CITY OF ALBUQUERQUE CAPITAL IMPLEMENTATION PROGRAM LANDSCAPE ARCHITECTURE AND CONSTRUCTION SERVICES	
TITLE: RICHLAND HILLS PARK IMPROVEMENTS PROJECT	
CONCEPTUAL GRADING AND DRAINAGE PLAN	
Design Review Committee	City Engineer Approval
City Project No. 566371	Zone Map No. C-12-Z
Sheet 4 of 15

CITY OF ALBUQUERQUE CAPITAL IMPLEMENTATION PROGRAM LANDSCAPE ARCHITECTURE AND CONSTRUCTION SERVICES	
TITLE: RICHLAND HILLS PARK IMPROVEMENTS PROJECT	
HORIZONTAL GEOMETRY PLAN	
Design Review Committee	City Engineer Approval
City Project No. 566371	Zone Map No. C-12-Z
Sheet 7	of 15

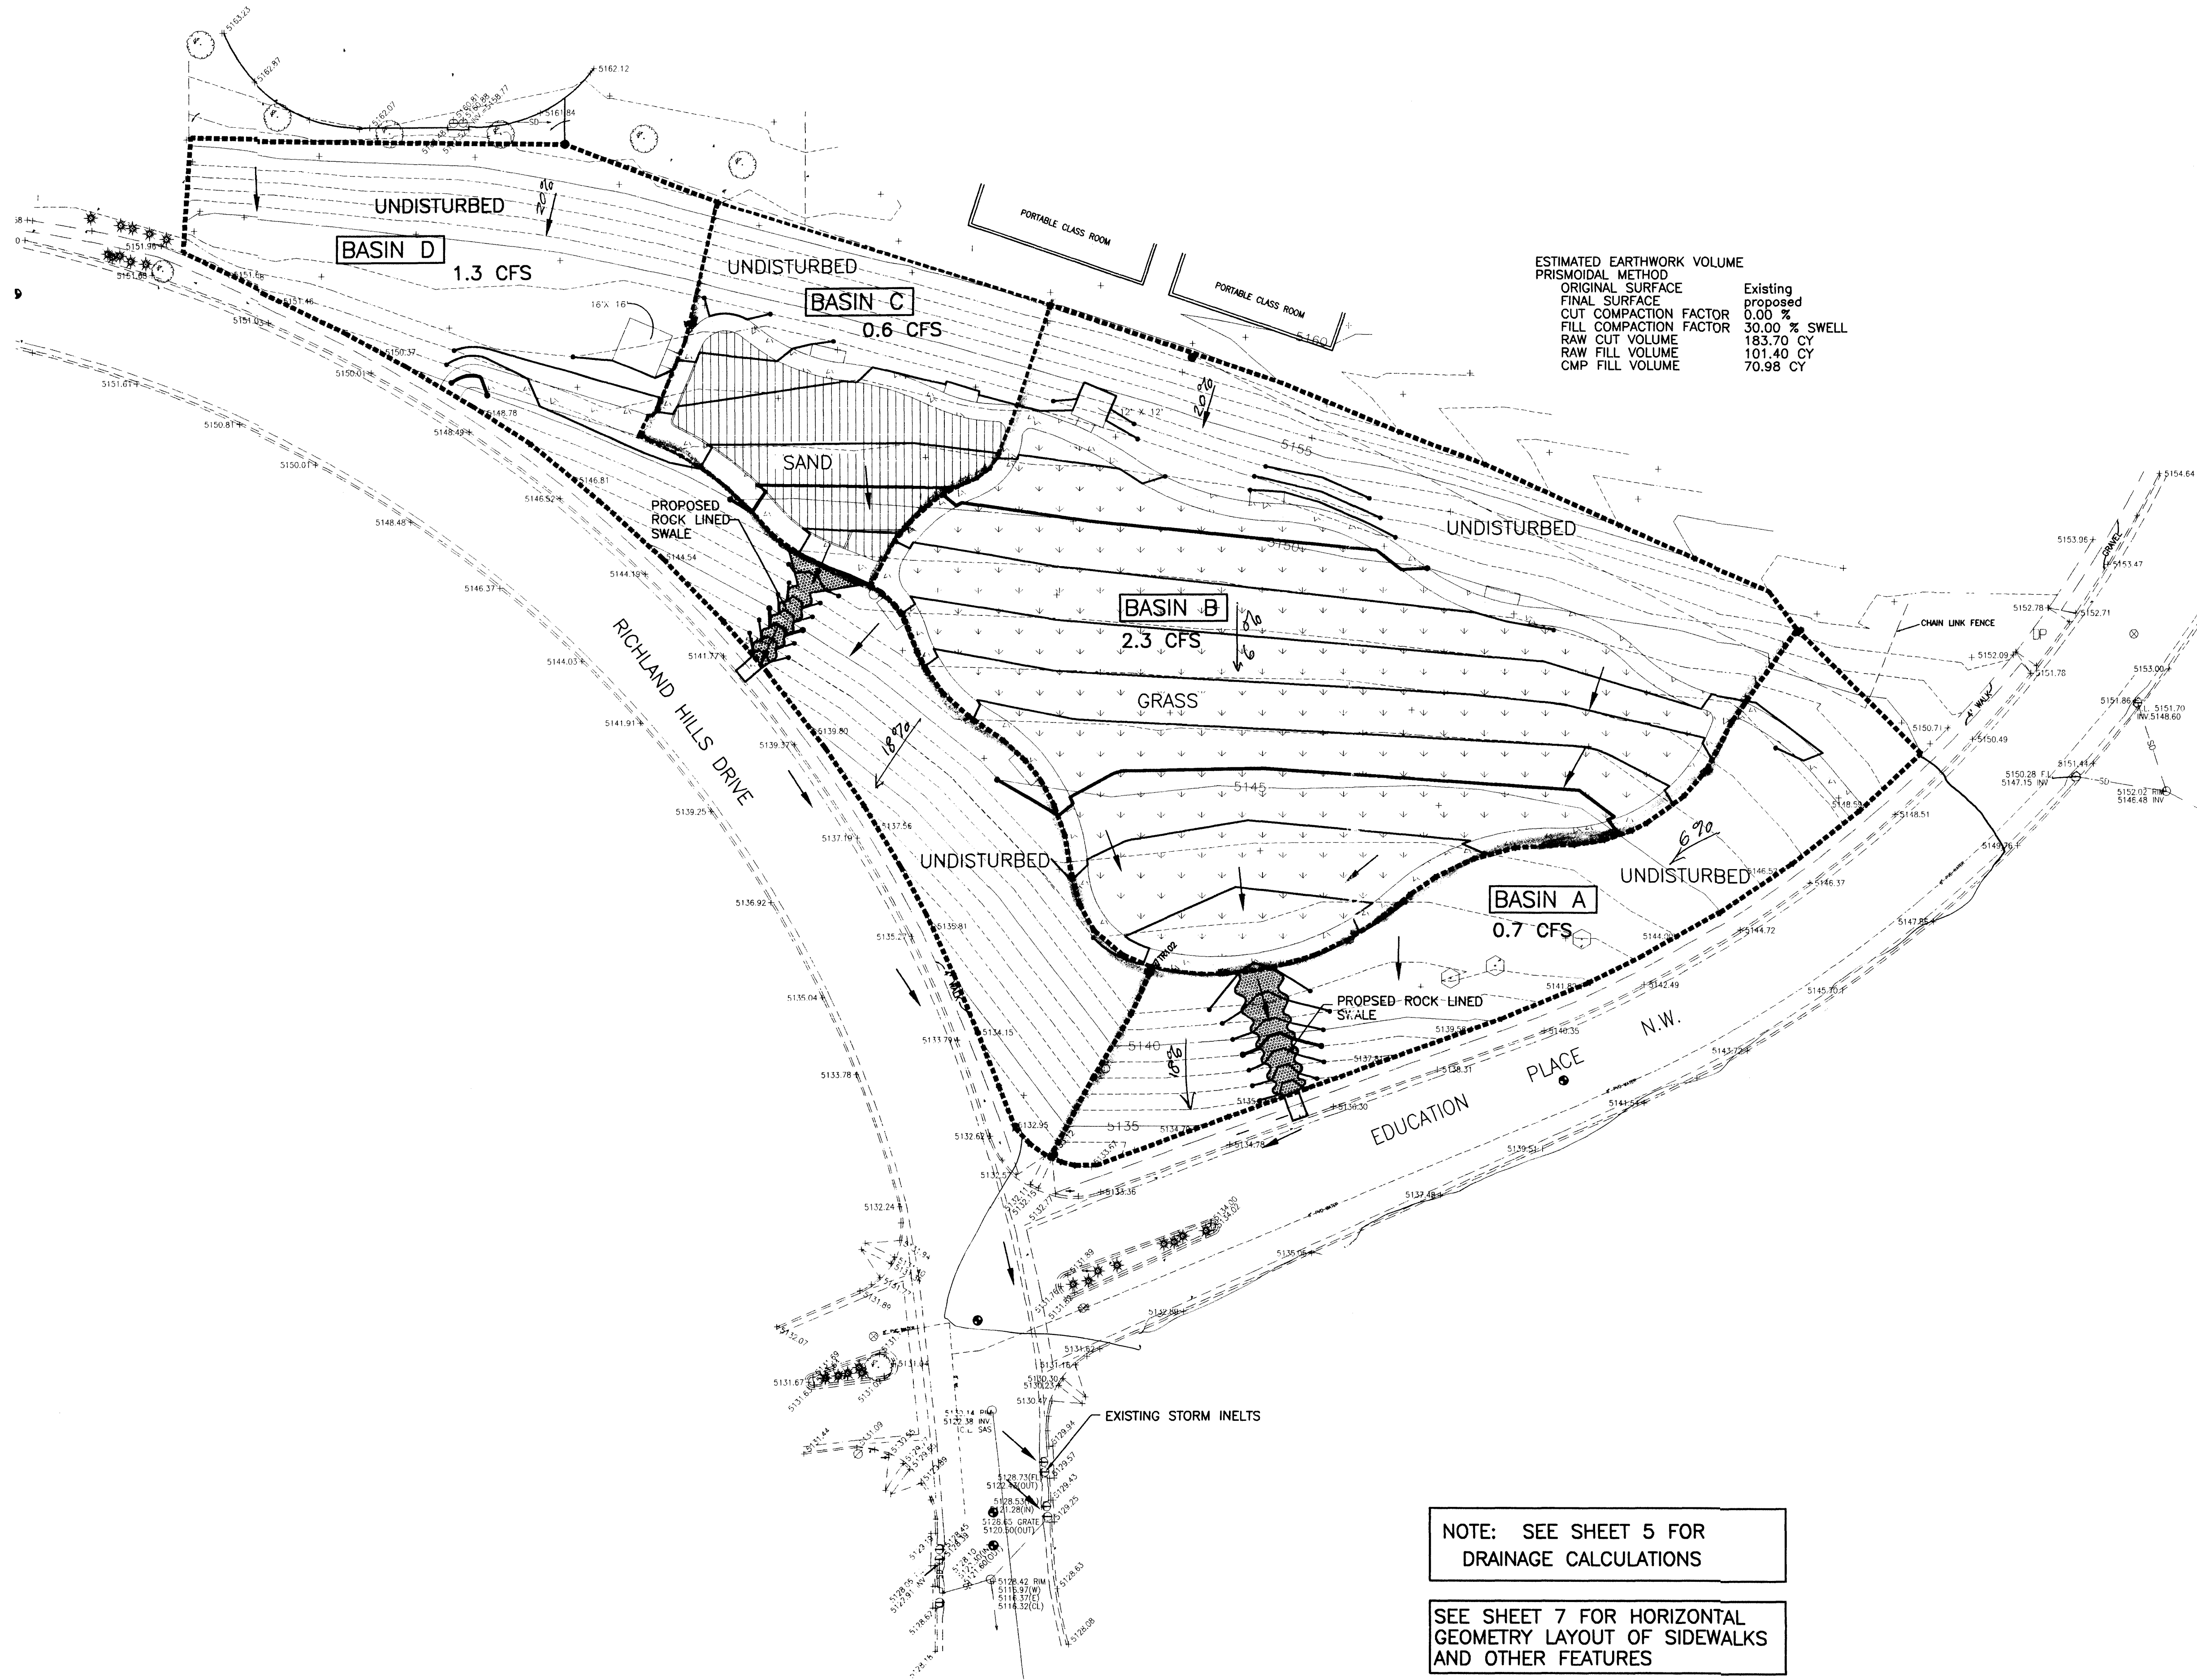
Q: sum of the SubBasins
